SSD 5207 - Netball Central : Site 107 Sydney Olympic Park Response to Issues raised in Submissions

Issue	Response	
Sydney Olympic Park Authority – Submission dated 24 Augus	st 2012	
Forecourt Design	It is understood that the issues around the forecourt design are largely resolved (refer Scott Carver drawing package attached), with the exception of the final lighting design (see comments below) and other relatively minor issues (balustrade detail for ramp).	
	It is understood that resolution of these matters will be discussed at a further workshop session with the Project Team and SOPA officers (which may achieve further resolution) but will ultimately be addressed via conditions of consent (to be recommended by SOPA).	
Signage Venue identification and way finding signage has not been shown as part of this application and it is recommended that venue and wayfinding signage be considered under a separate application.	The provision of way finding signage is a matter for SOPA and it is understood that it will ultimately serve the Sports Centre, Netball Central and any future development on the adjacent Site 13. Provision has been made for location of way finding signage within the for

Proposed Site / Public Domain Interface Plan

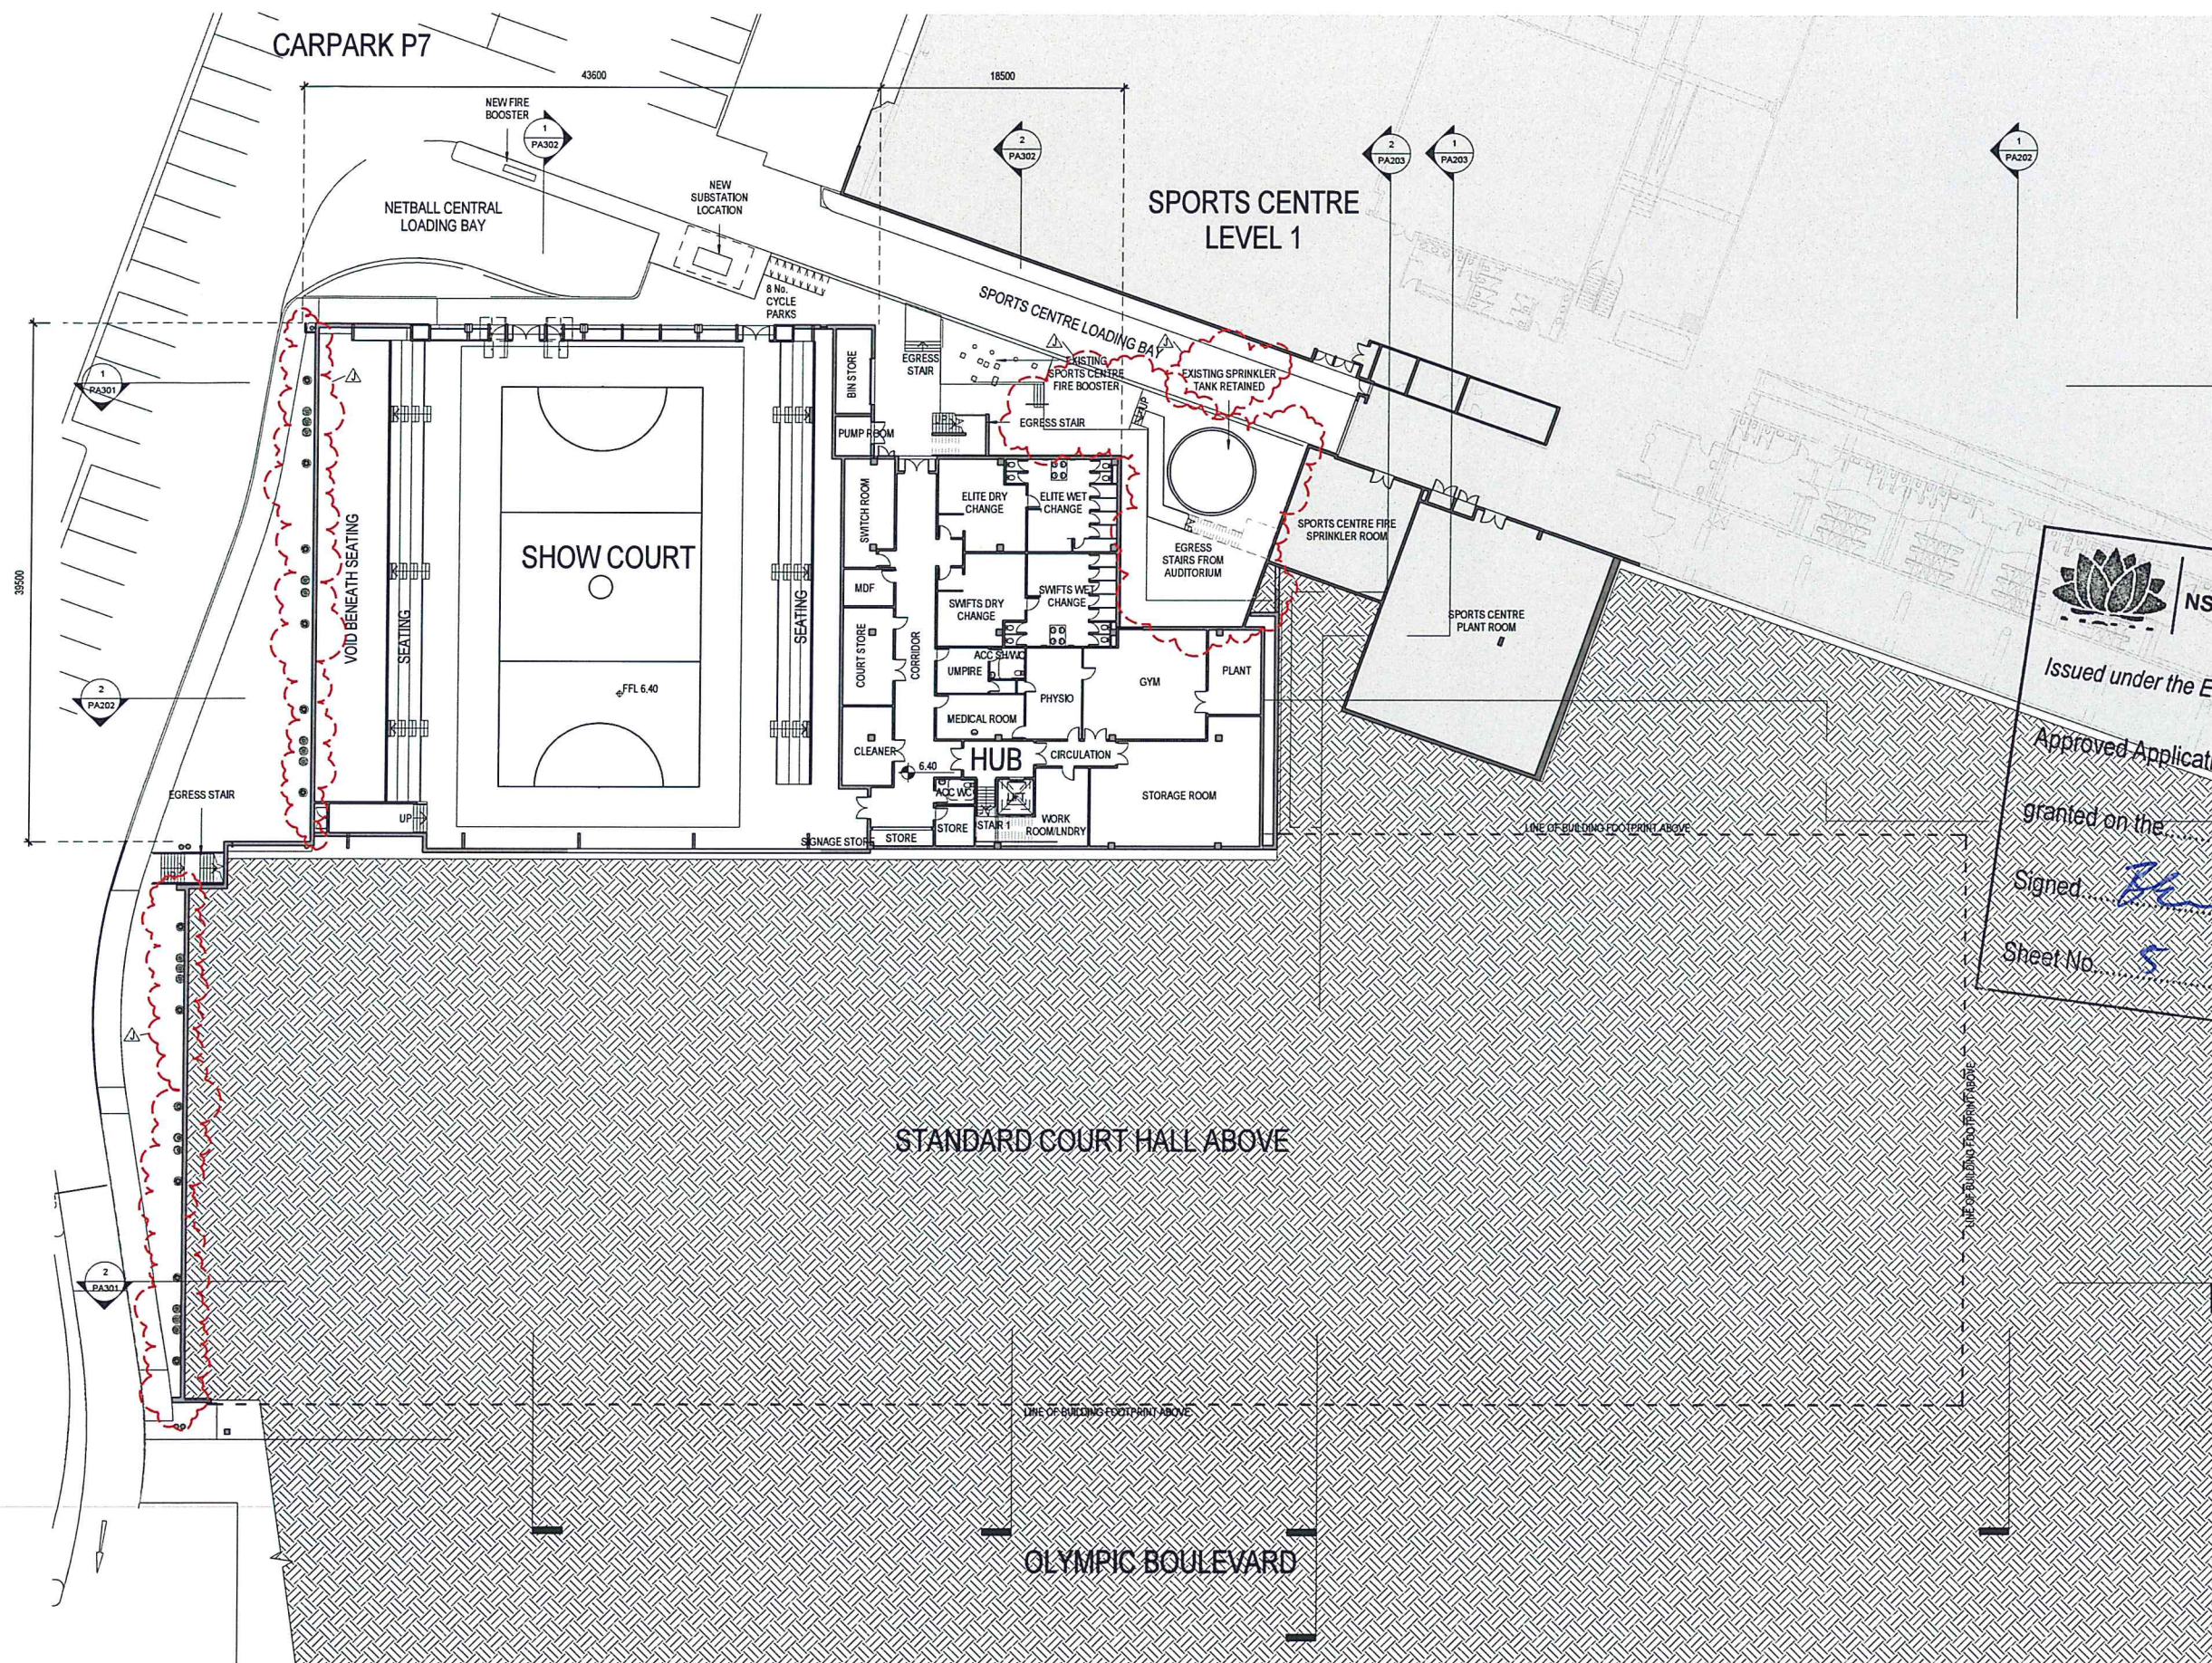
- The relocated driveway which provides access to P7 car park is too close to Netball Central and awkwardly positions in relation to the roundabout and adjacent Shirley Strickland Ave intersection, resulting in potentially dangerous approach angles.
- The proposal for larger vehicles exiting from P7 car park to manoeuvre around the roundabout before travelling north along the Boulevard is not supported.
- The use and arrangement of the kerbsides along Olympic Boulevard to respond to the relocated entry (including accessible parking, bus drop off and merchandising vehicle parking) is not addressed in the submission.

- The driveway alignment is to be tested by a swept path analysis to determine optimal location and alignment of the driveway.
- The Olympic Boulevard kerbside area is to be included on drawings together with the revised forecourt design, and is to show the relocated bus set down, merchandising vehicle parking and accessible parking bays.
- The application is to demonstrate that the proposed P7 car park design will allow large scale vehicles into / out of the loading docks at the Sports Centre without affecting routine traffic movements in the remainder of the P7 car park.

The proposed driveway alignment has been designed to Australian Standards 2890.2 for an access to an off-street commercial vehicle facility. This process involved swept path analysis (refer **Attachment 1**) of the entry for the largest vehicle expected to utilise this driveway, which in this case constituted a 19m Articulated Vehicle.

Consideration was given to the awkward position of the access in relation to Shirley Strickland Avenue, with the approach to the roundabout angled to provide the most amount of sight distance possible in that location. The existing square aspect of the intersection of Olympic Boulevard and Shirley Strickland Avenue does not allow long vehicles to turn left out of the development.

Discussions have been undertaken with SOPA regarding the most appropriate kerbside parking treatment. It was agreed to retain the current short term public parking at the far north (including accessible spaces) and extend the bus set down south between this point and the roundabout. It is further understood that details of the kerbside parking can be documented as part of the Public Domain Plan which SOPA will require and which will be recommended for inclusion as condition of consent.

1 South Elevation (Court Halls)  
1:250

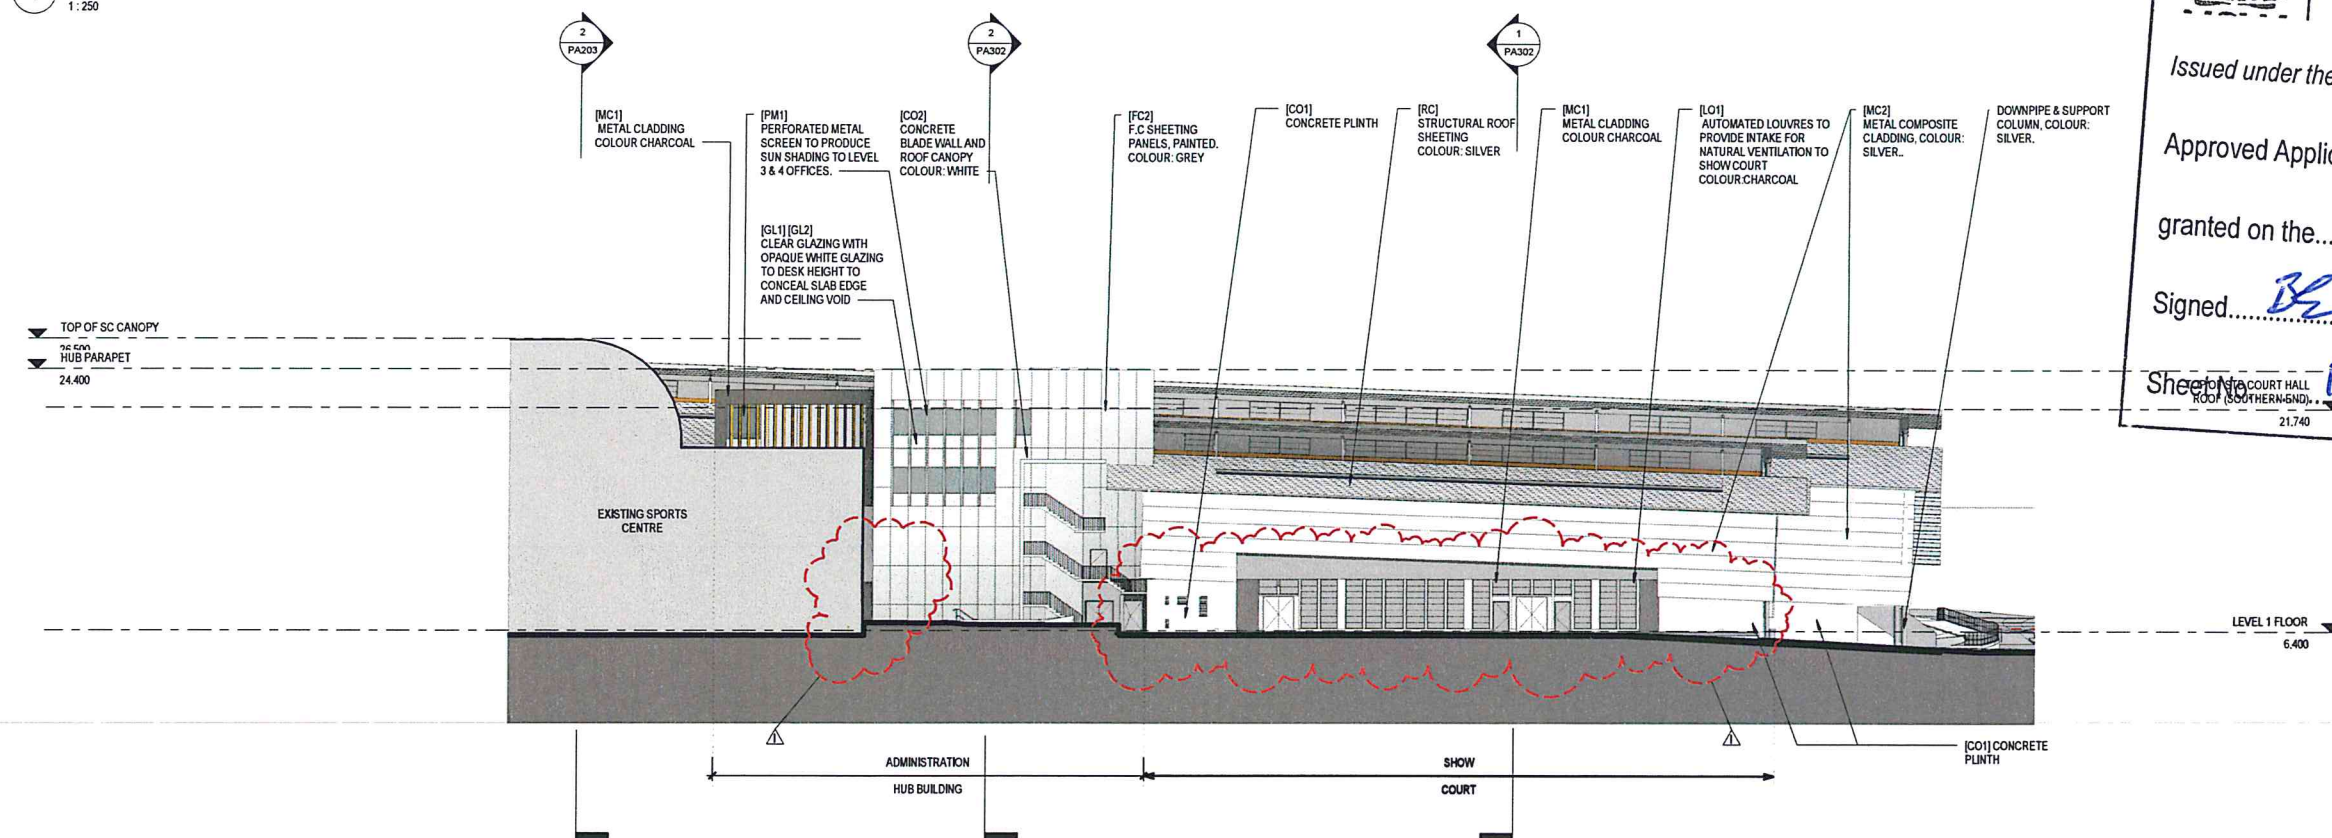
Issue	Response
Stormwater	
The proposed stormwater drain / detention channel on the southern side of the Netball Centre is both dangerous and unsightly and is not supported by SOPA. In addition, the submission does not demonstrate that thi channel has the capacity to provide adequate on-site SW detention.	Attached for SOPA's information is the following information: Details of proposed on-site detention prepared by ARUP (refer Attachment 2); An alternate solution for the integration of roof drainage and the treatment
Roof drainage is not well resolved, with an excessive number of downpipes dominating the southern face of the building.	of the southern elevation of the building is illustrated at Attachment 3 prepared by Scott Carver Architects; and
Harvesting / reuse of this stormwater (eg. for toilet flushing, irrigation) is not currently proposed, with all rainwater collected from the substantial new roof area ultimately intended to flow to Boundary Creek (EIS p73).	Advice from ARUP regarding water quality (refer Attachment 4).

Attachment 3 Southern Elevation Scott Carver Architects

Southern Elevation of Netball Central Court Halls, with amended catchment detail serving downpipes.
